Date: 13-Jul-2026
Our Ref: 2025/92161

**Application for Approval of Details Reserved by Condition
Town and Country Planning Act 1990
Planning (Listed Buildings and Conservation Areas) Act 1990**

**Discharge of details reserved by conditions 4 (finished floor levels), 5 (coal investigation), 6 (coal remediation validation), 7 (phase 1 contamination), 8 (phase 2 contamination), 11 (contamination Verification Report), 12 (CEMP), 13 (noise), 14 (Arboricultural Method Statement), 15 (CMP), 16 (highway survey), 17 (visibility), 18 (Off-site highway improvements), 19 (estate streets), 20 (waste collection), 21 (highway structures), 24 (bin storage), 25 (bicycle storage), 26 (temporary surface water), 28 (drainage management and maintenance), 29 (CEMP: Biodiversity), 30 (landscape), 34 (solar panel array), 35 (materials), 38 (crime prevention) on previous permission 2024/92281 for erection of 23 dwellings
Land adj, 17, Whitehall Road West, Birkenshaw, BD11 2LS
Application Number: 2025/92161**

SITE PLAN

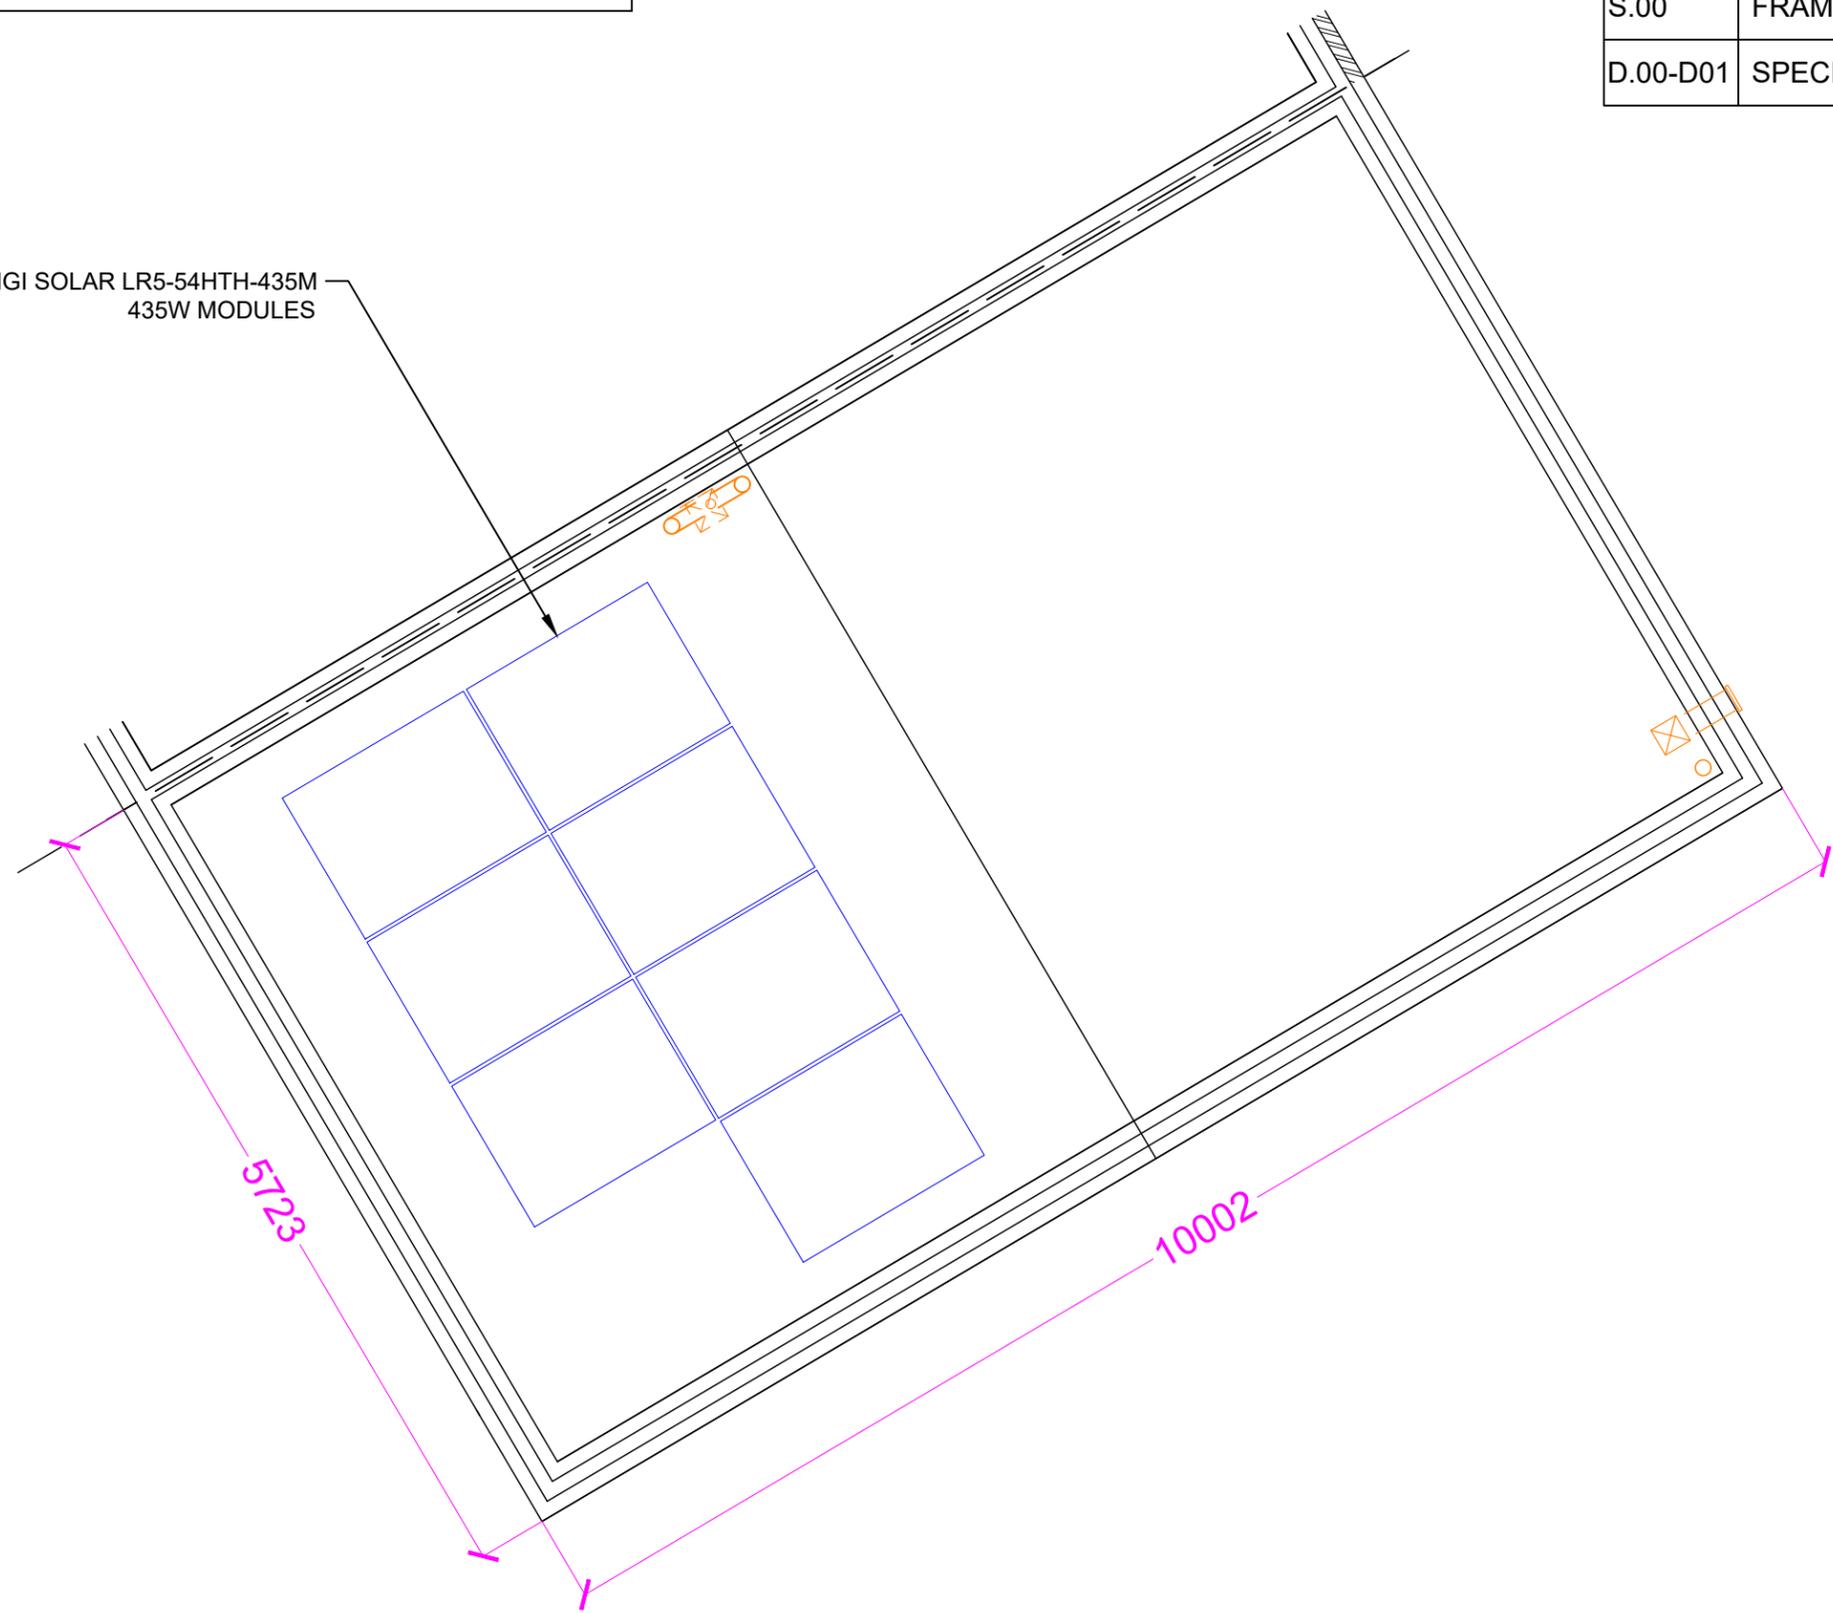
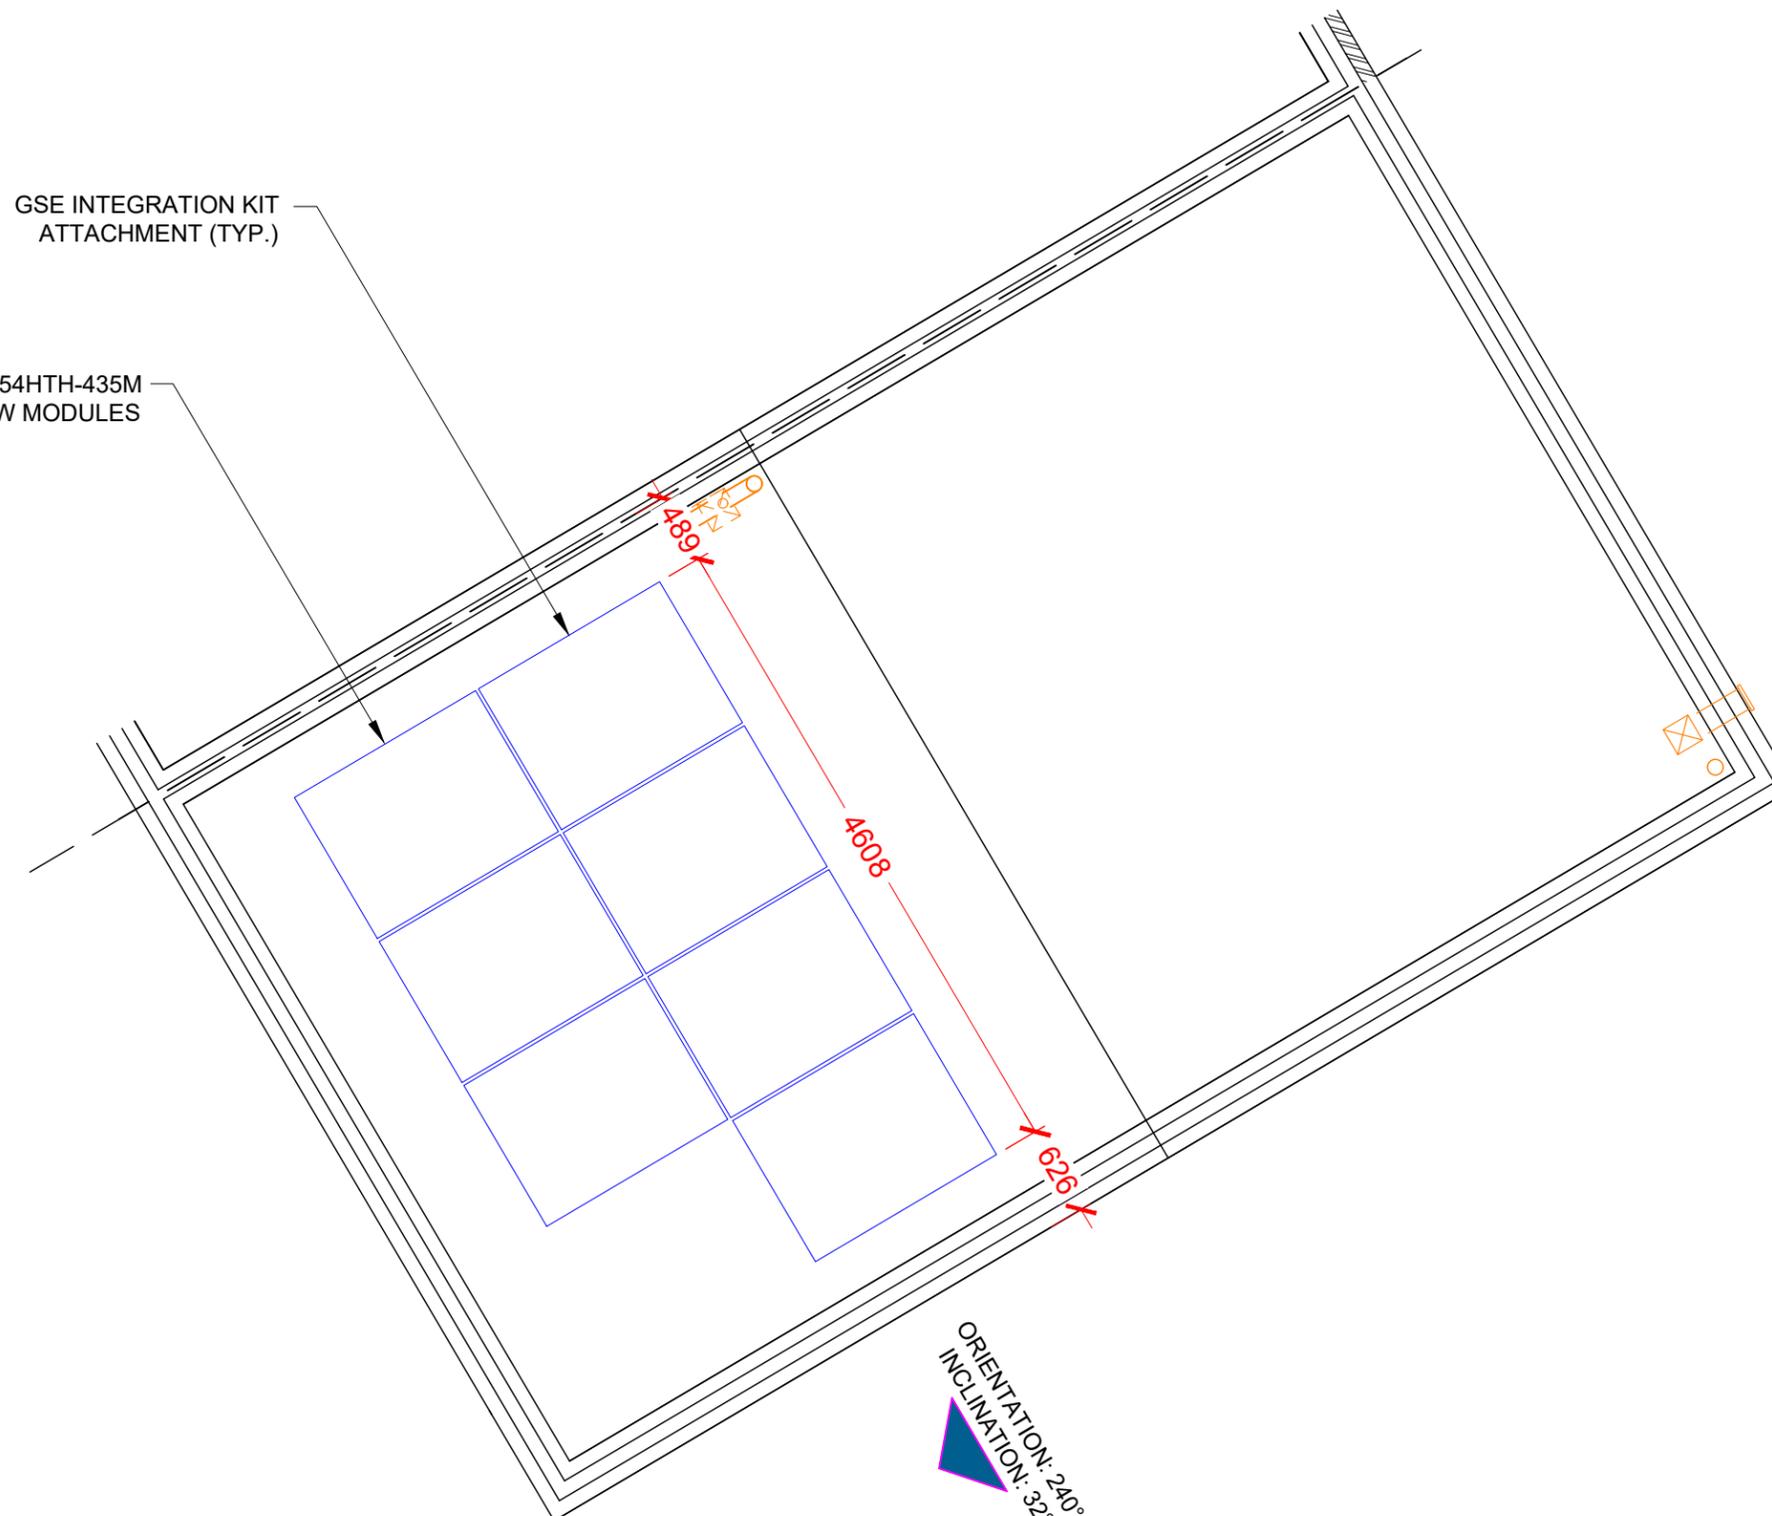
- A set of plans for each house type. These are referenced A.00, A.01, S.00, D.00, D01, and include roof plans, method of attachment, and technical specifications. For the avoidance of doubt, these packages of plans have the 'Project Names' of:
 - Whitehall Road (Dartmouth)
 - Whitehall Road (Wharfedale)
 - Whitehall Road (The Arundel)
 - Whitehall Road (The Bamburgh Jedburgh)
 - Whitehall Road (The Cheltenham)
 - Whitehall Road (The Gosford)
 - A plan titled Site Plan – PV Locations, reference 2306/03/001B (20/02/26).

The submitted details show that each dwelling would have an array of 7 no. solar panels on one roof slope (in each case this would be the roof slope with a southerly aspect) which would be capable of generating 3.05kW in total.

It is considered that the measures shown on the plans, for each dwelling, are acceptable for the purposes of this condition and are hereby approved. The initial requirements of the condition will be complied with by the scheme being implemented and made operational before any new dwelling to which it relates is first occupied.
